Building Inspections - Re: Fast Track Permit - 98 Hamblet Ave.

From: Jeanie Bourke
To: Brad Post; Building Inspections
Date: 11/19/2015 11:52 AM
Subject: Re: Fast Track Permit - 98 Hamblet Ave.

Per our conversation this morning and my cursory review of the plans, I will allow this project to be eligible for Fast Track status with the following additional information. Submit this email as a pdf document as verification of this decision.

FOUNDATION & FIRST FLOOR FRAMING PLAN
1/4" = 1'-0"

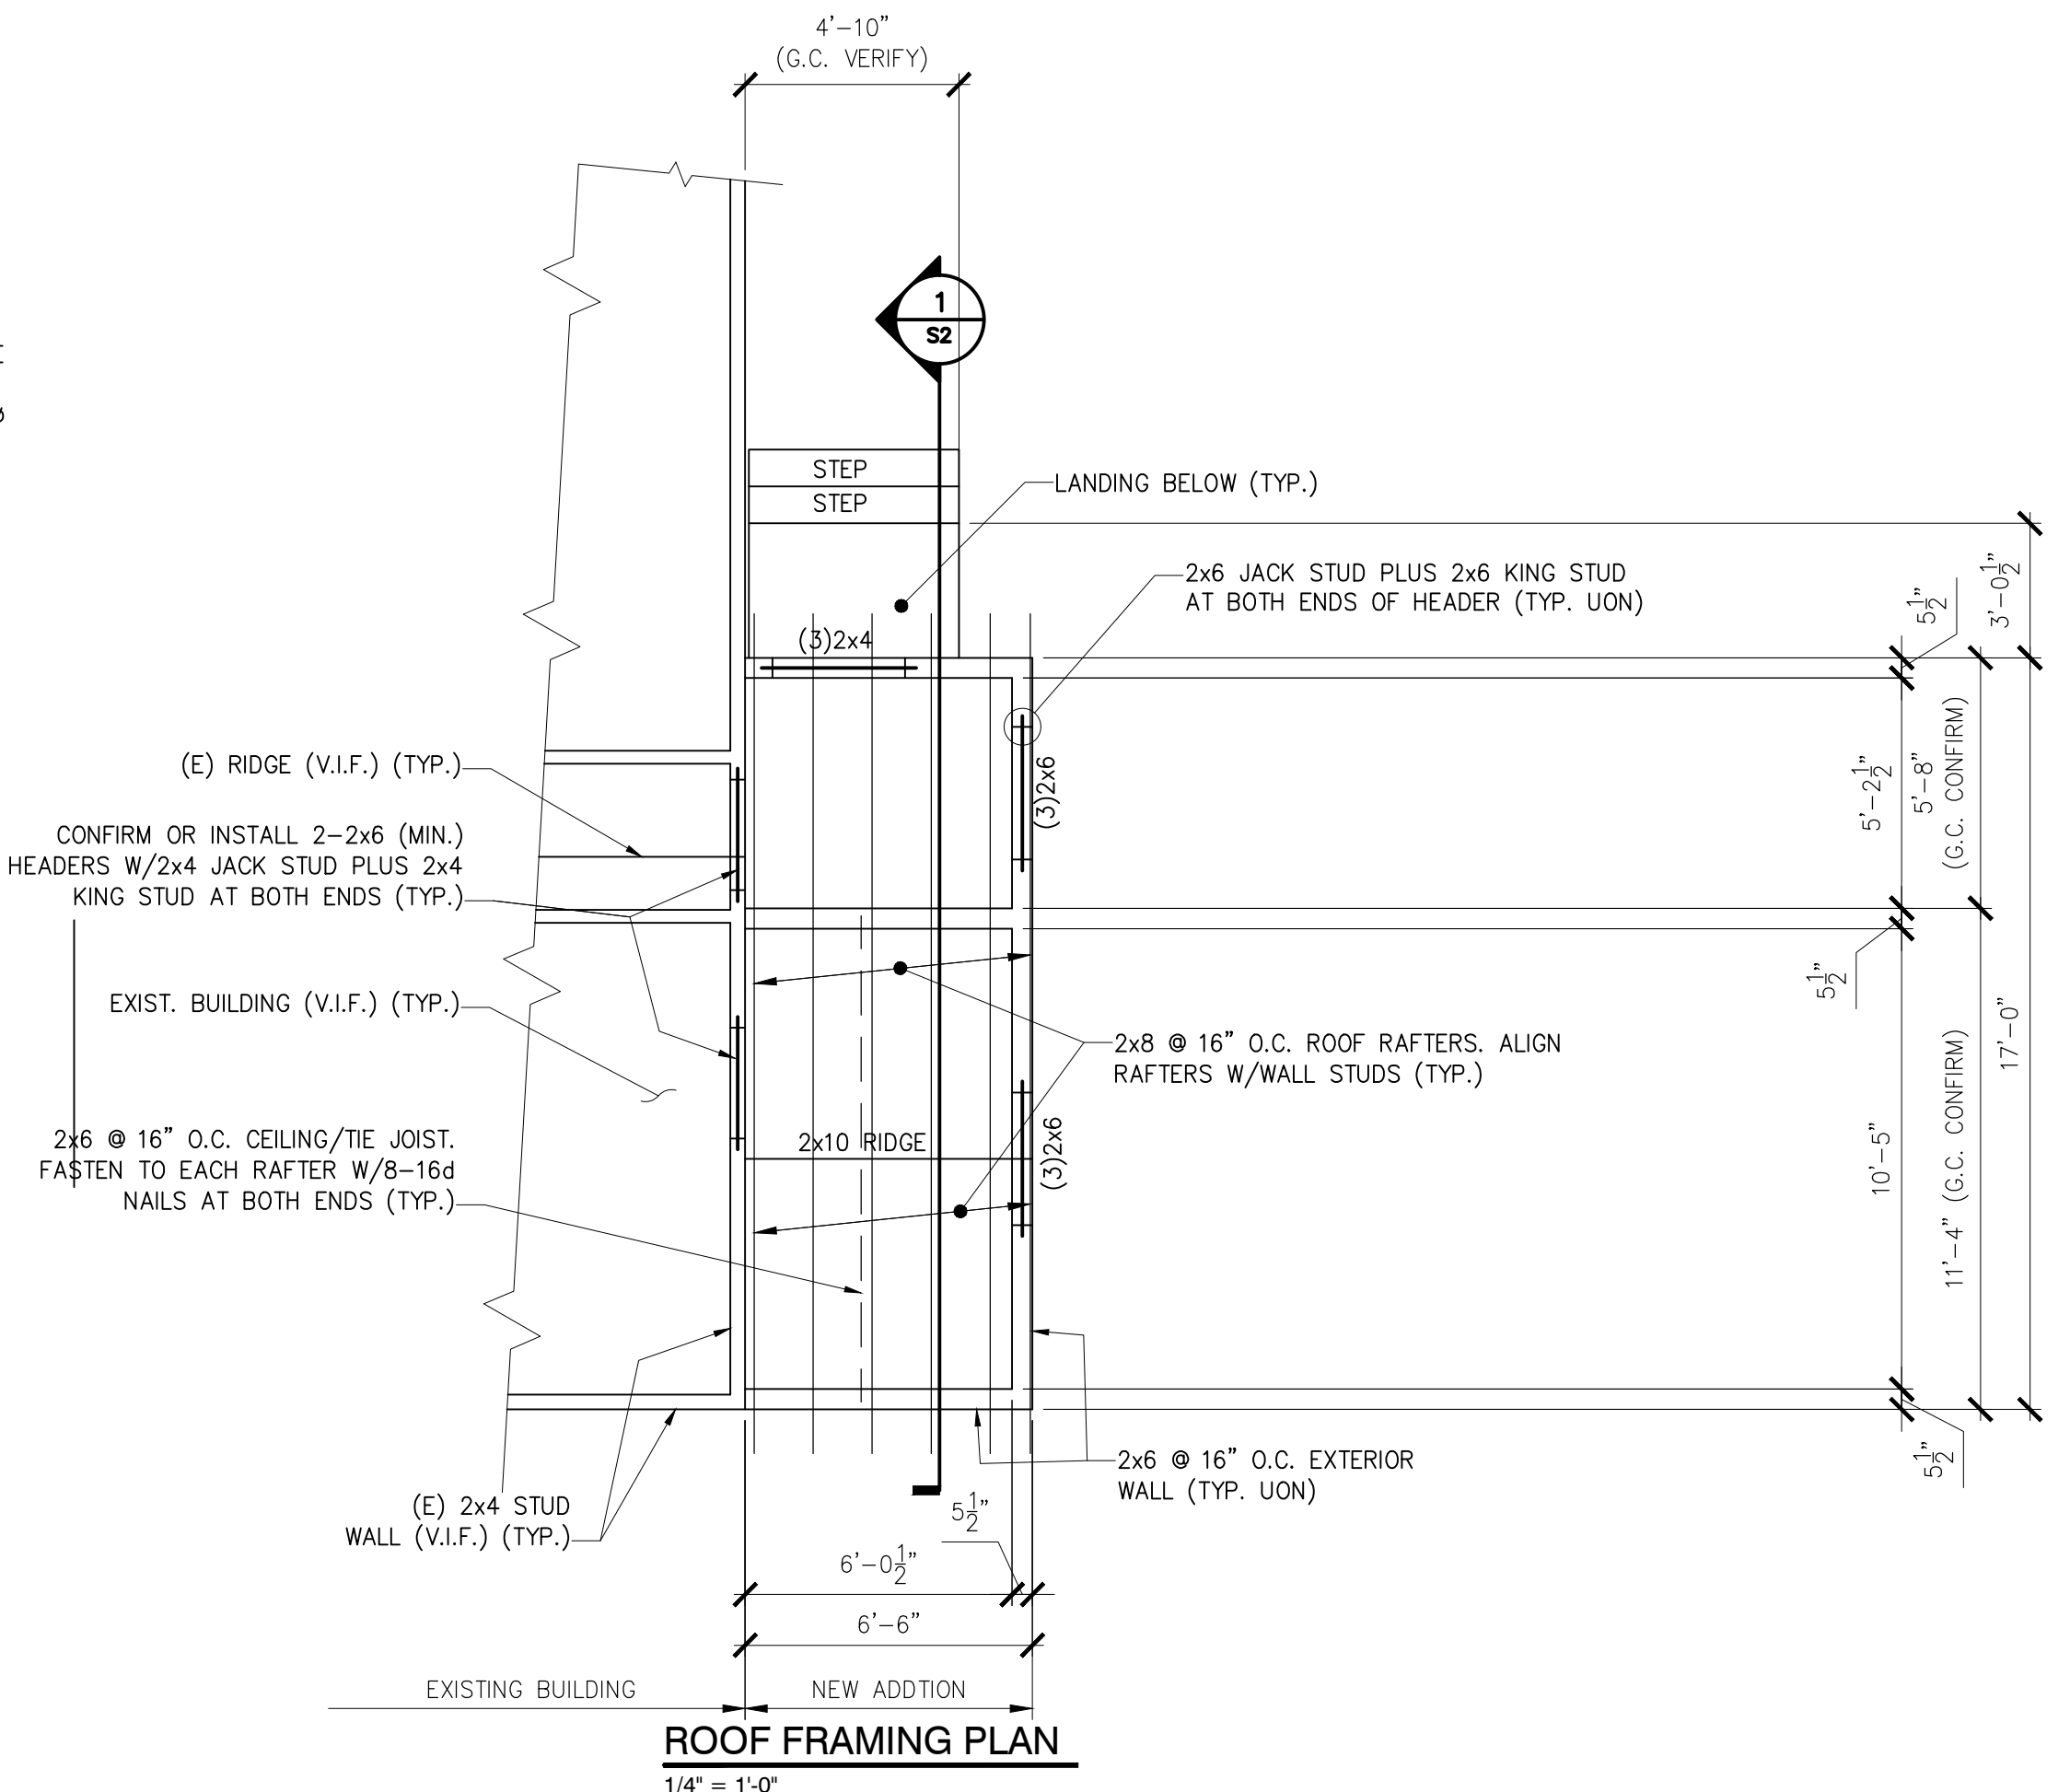
1. In lieu of full architectural stamped plans, provide a letter from an engineer approving the structural design.
2. Provide a floor framing plan including sona tube placement, girder sizes and fastening/anchor details.
3. Revise the proposed floor plan at the existing 1st to 2nd floor/basement stair to clearly show both stair direction of travel and remove the wall at the landing to the first floor.

I had Joe Leasure do the framing detail along with his stamped structural notes and am attaching them here along with the floor plan with the corrected interior stair direction and wall adjustment. I believe you have all the initial paperwork I submitted for the fast track permit. Please let me know you have the necessary pdf's to move forward with the fast track.
